From: Martin Turley [REDACTED]
Sent: 12 September 2019 10:16
To: Simon Davis <Simon.Davis@arun.gov.uk>
Subject: Subject: AW/237/19/PL Former Ship Inn

Title
Site Location Plan with Vehicle Tracking : Articulated Vehicle

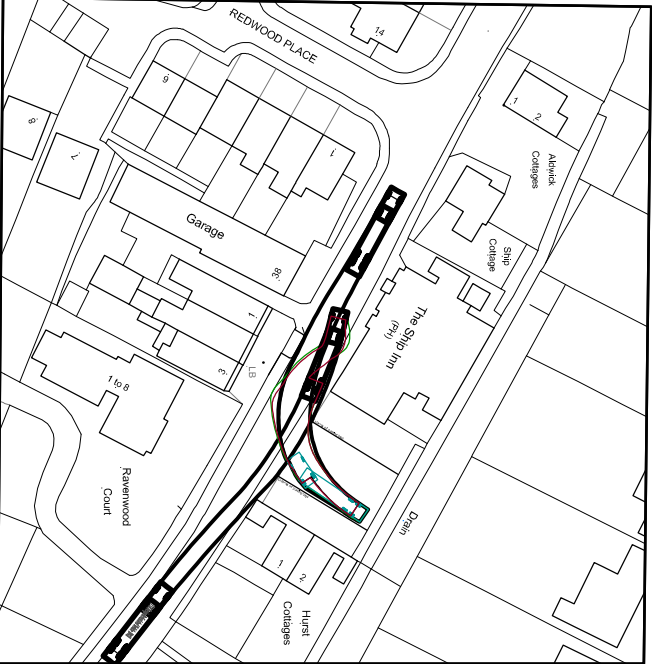
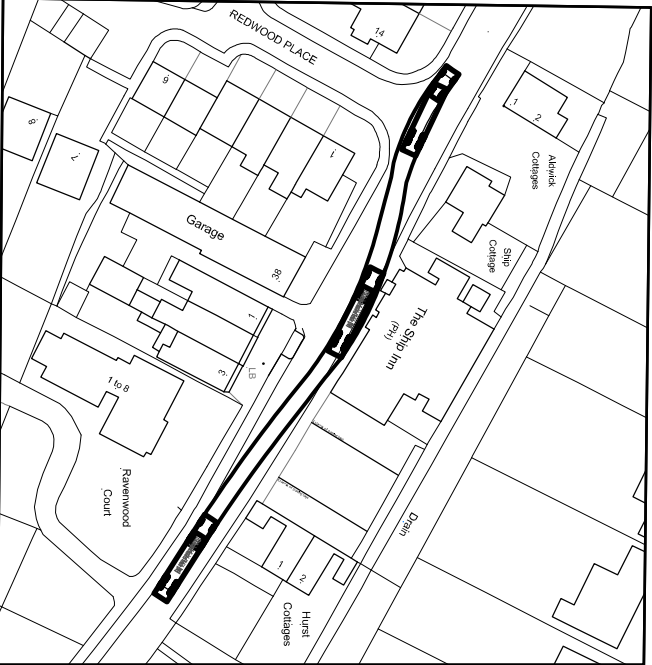
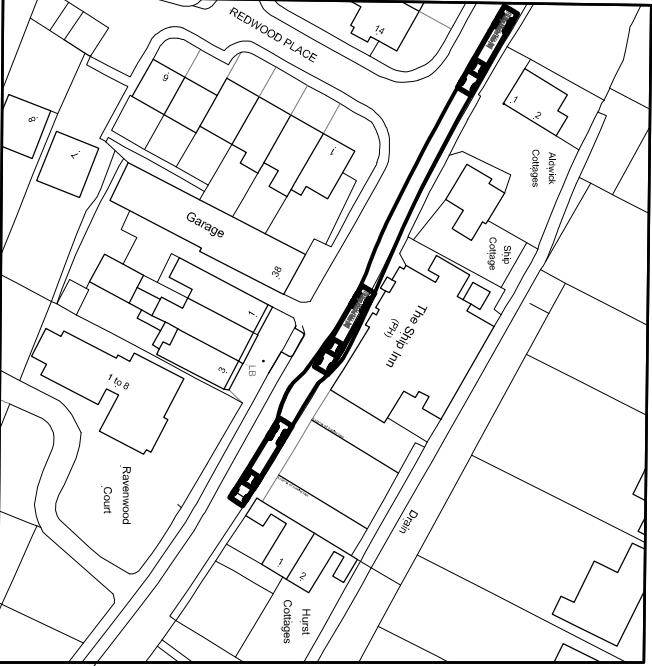
The delivery schedule/arrangements will most definitely cause a considerable nuisance to local people. Its hard to imagine how a 38ft, 28 tonne articulated truck will be able to negotiate deliveries without serious health and safety issues, 4 times a week. Add to this the 4 deliveries by 3.5 Tonne box van, 3 deliveries by 18 Tonne rigid vehicles, 5 deliveries by 26 Tonne refrigerated vehicles, 12 deliveries by 18 Tonne rigid vehicles and 7 transit vans each week and I'm sure you'll agree that things would be very miserable for local residents. Their health, safety and well being will be considerably challenged. Its also worth noting that the estimated 35 delivery slots per week is considerably greater than the three deliveries a day (21 per week) that Morrison's had permission for.
